**Marine
Management
Organisation**

MMO Reference: DCO/2022/00007
Planning Inspectorate Reference: EN010125
Identification Number: 20050160

Planning Act 2008, RWE Renewables UK Dogger Bank South (West) Ltd and RWE Renewables UK Dogger Bank South (East) Ltd Proposed Dogger Bank South Offshore Wind Farms Order

Deadline 5

Figure: 2-2	Drawing No: PB2340-MAR-OF-ZZ-DR-Z-0013	
Co-ordinate system: WGS 1984 UTM Zone 31N	Page Size: A3	Scale: 1:950,000
Project: Dogger Bank South Offshore Wind Farms	Report: Heat Mapping Report: Atlantic Herring and Sandeel

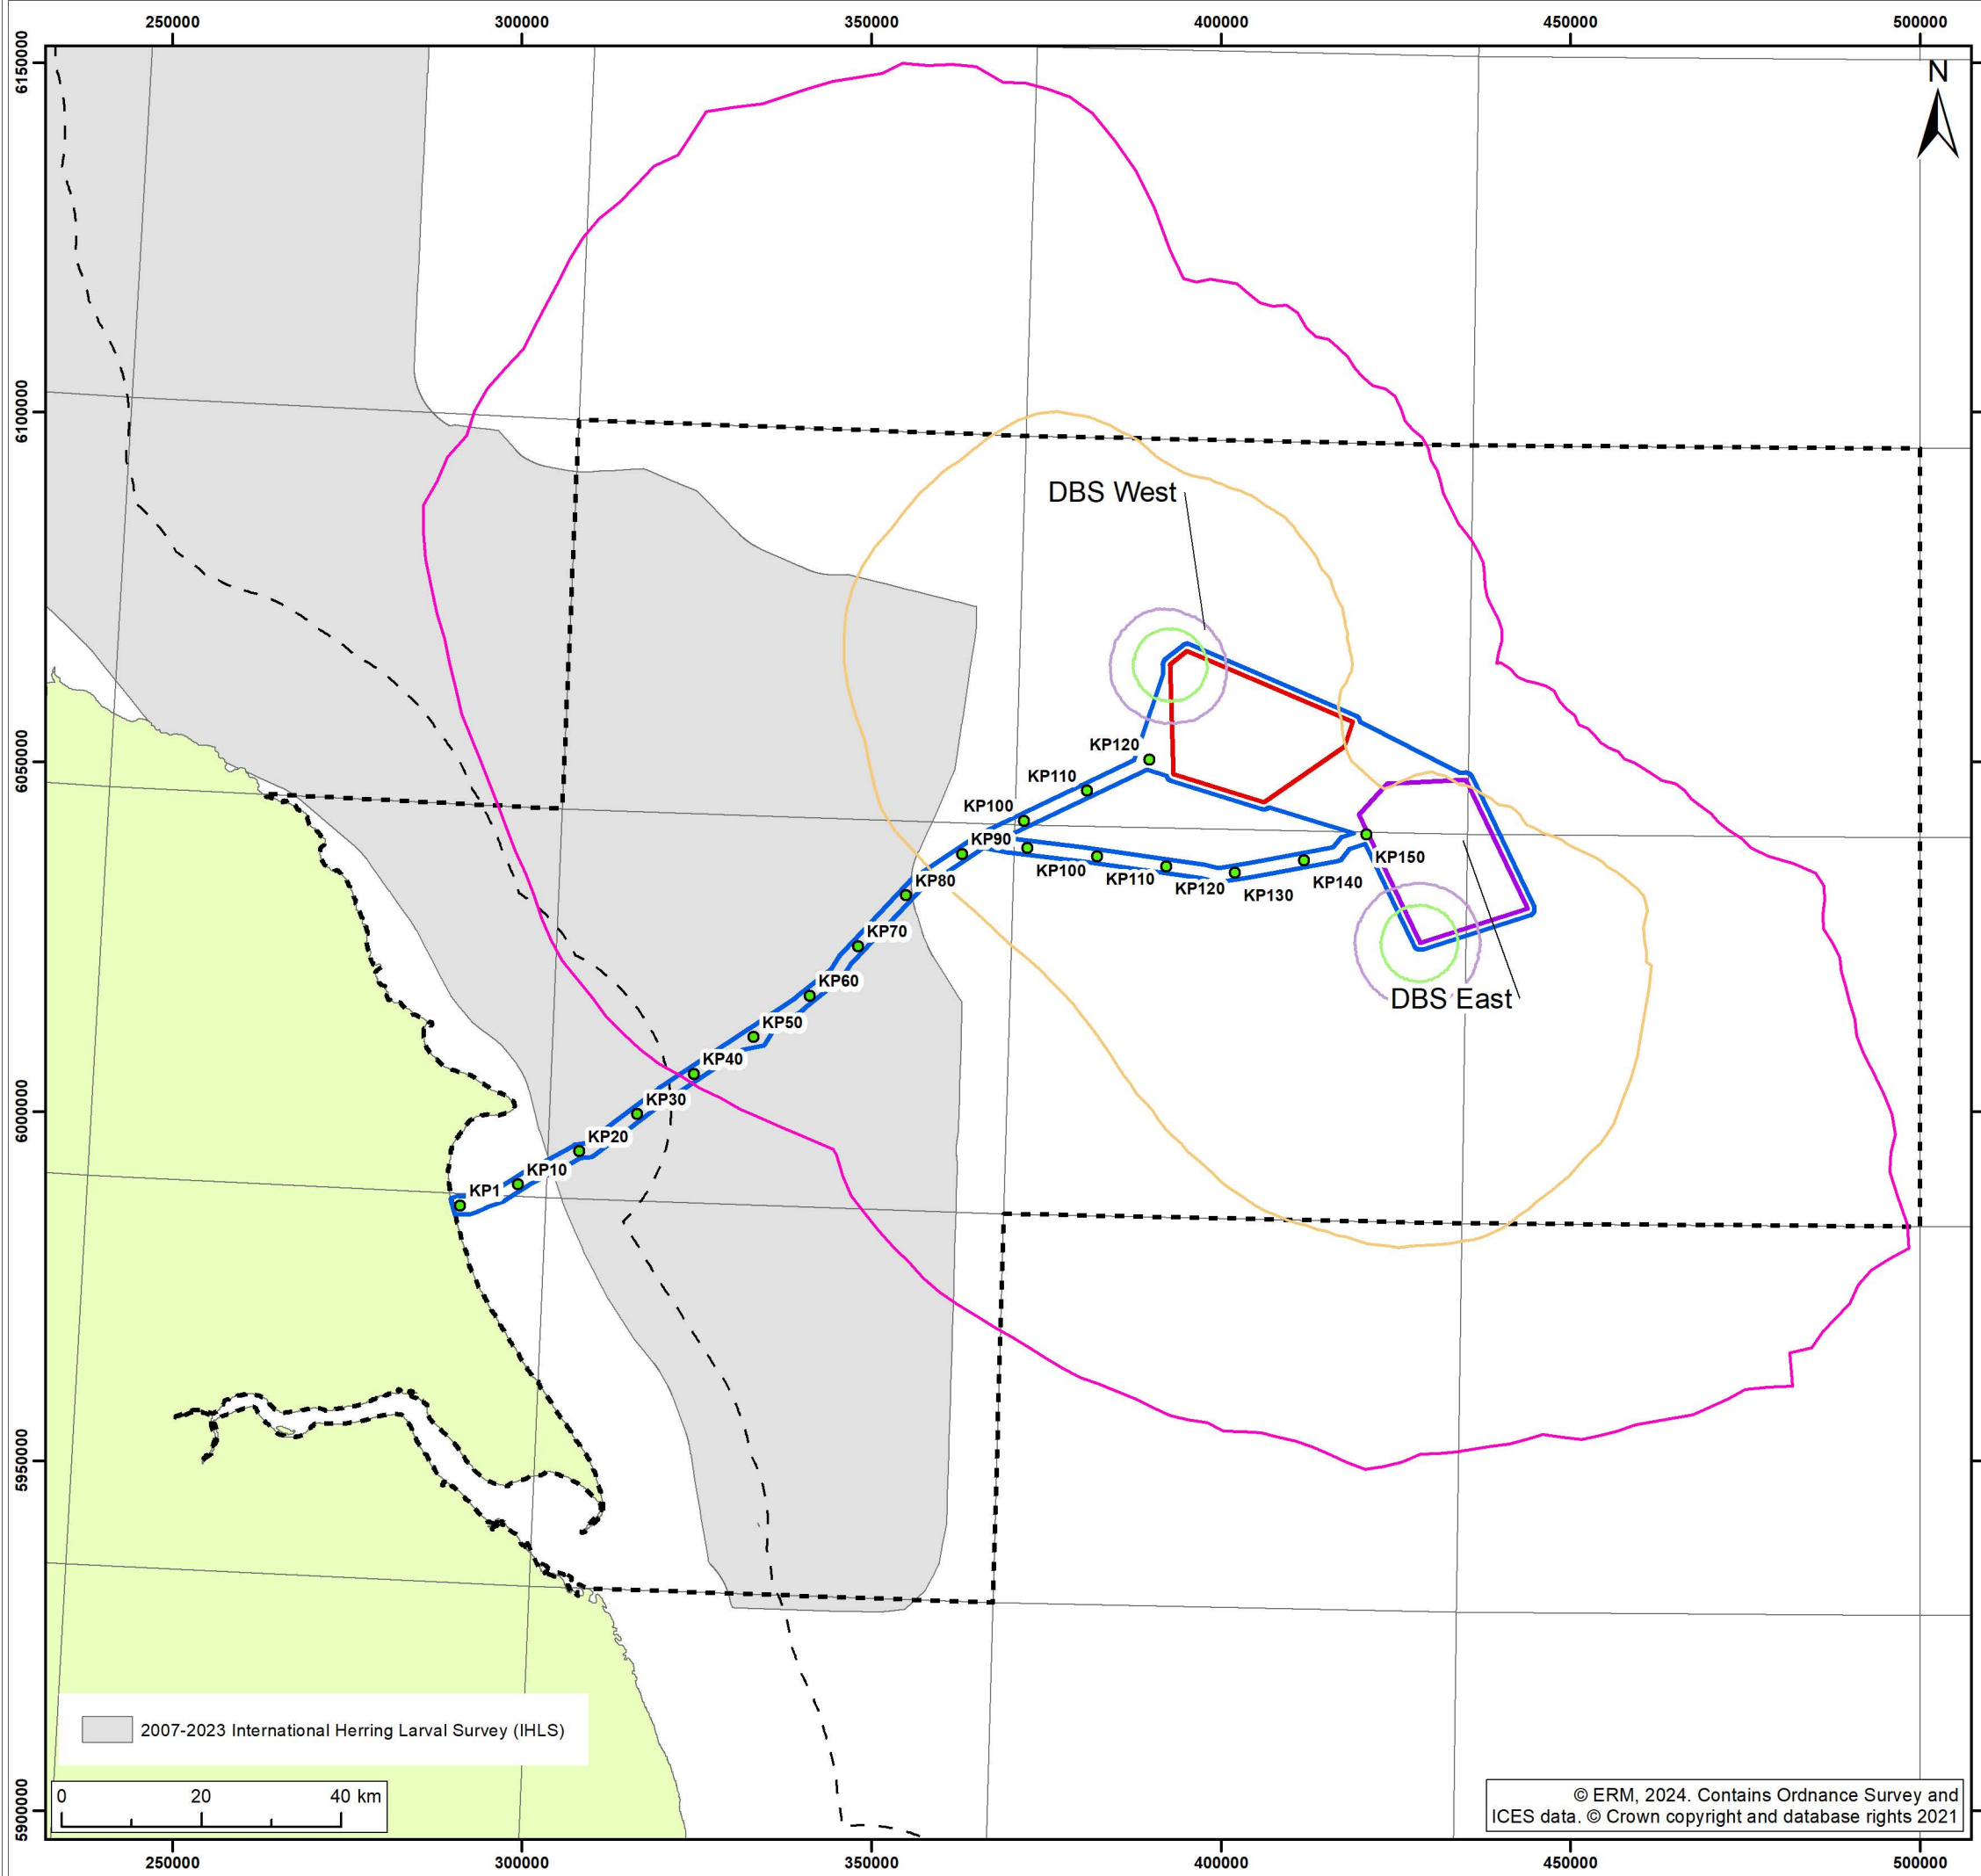
- 1.7.4 In response to the Applicants assertion in REP2-061:22 that “for assessing the potential for a significant effect from TTS, the International Herring Larvae Survey (IHLS) data shows that the overlapping potential spawning habitat is not highly productive” as shown by Figure 2.7 of the Heat Mapping Report: Atlantic Herring and Sandeel, the MMO advised previously that the presentation of this figure should be amended so that the data can be more clearly interpreted. As outlined section 1.7 of REP4-115, the main issue with Figure 2.7 is that the Applicant has aggregated 15 years of IHLS data into a single plot which does not fully represent the spatial and temporal fluctuations in herring spawning intensity across the spawning ground over the time period. It is possible for areas of herring spawning grounds where spawning activity was previously low to be recolonised and so it is important to see these data presented as a separate map for each individual year of IHLS data, so that the relative importance of the spawning habitat which underlies the ECC can be clearly examined and assessed.

Figure 2-1: The location of International Herring Larval Survey Sampling Stations and underlying EMODnet 1:250k Seabed Sediment Type. Station numbers (ST) and Kilometre Points (KP) are presented for reference

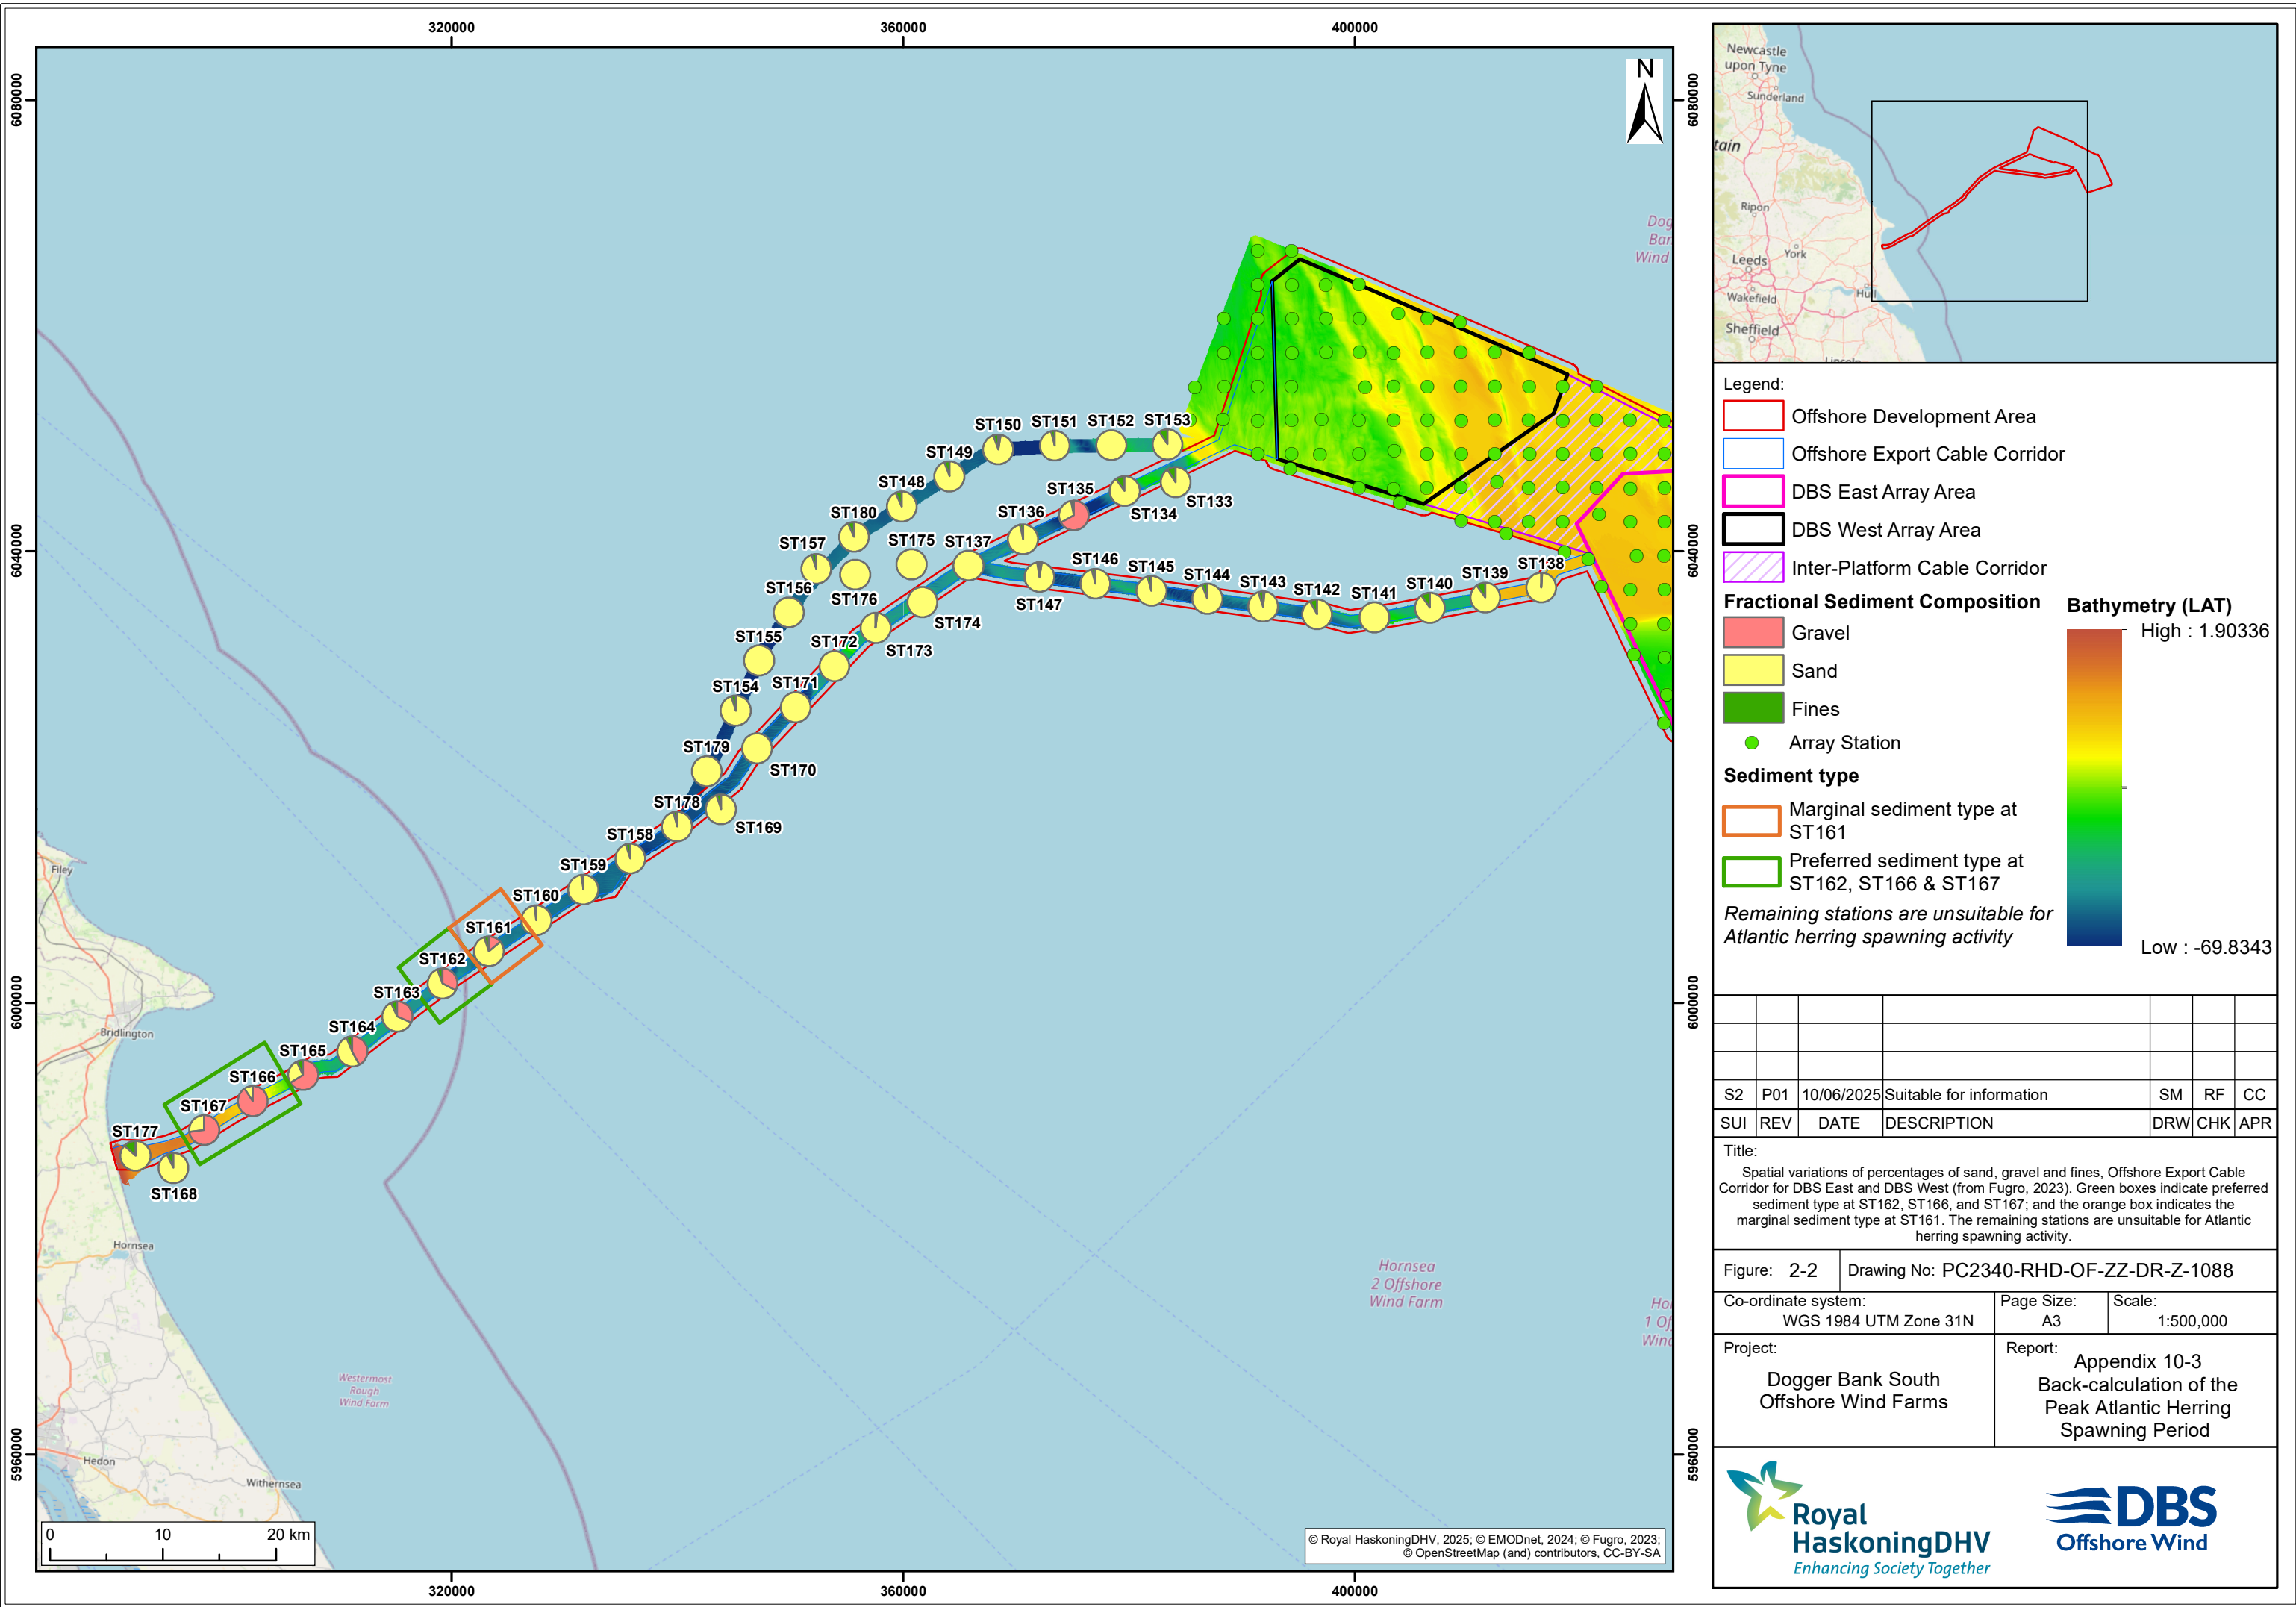
1.7.12 There are several points of concern with the Applicant's response that the recommended herring spawning restrictions are not necessary. Firstly, The Applicant has referenced some seabed temperature data in their responses provided in REP3-028, however these responses are not comprehensive enough for the period of the recommended herring spawning restrictions to be temporally refined at this stage. If the Applicant wishes to carry out a back-calculation approach to accurately temporally refine the recommended restrictions in a way which is supported by appropriate evidence and literature, then they should provide a dedicated technical note which details their calculations. The MMO have provided instructions on how to appropriately carry out the back-calculation approach in points 1.7.14-1.7.28.
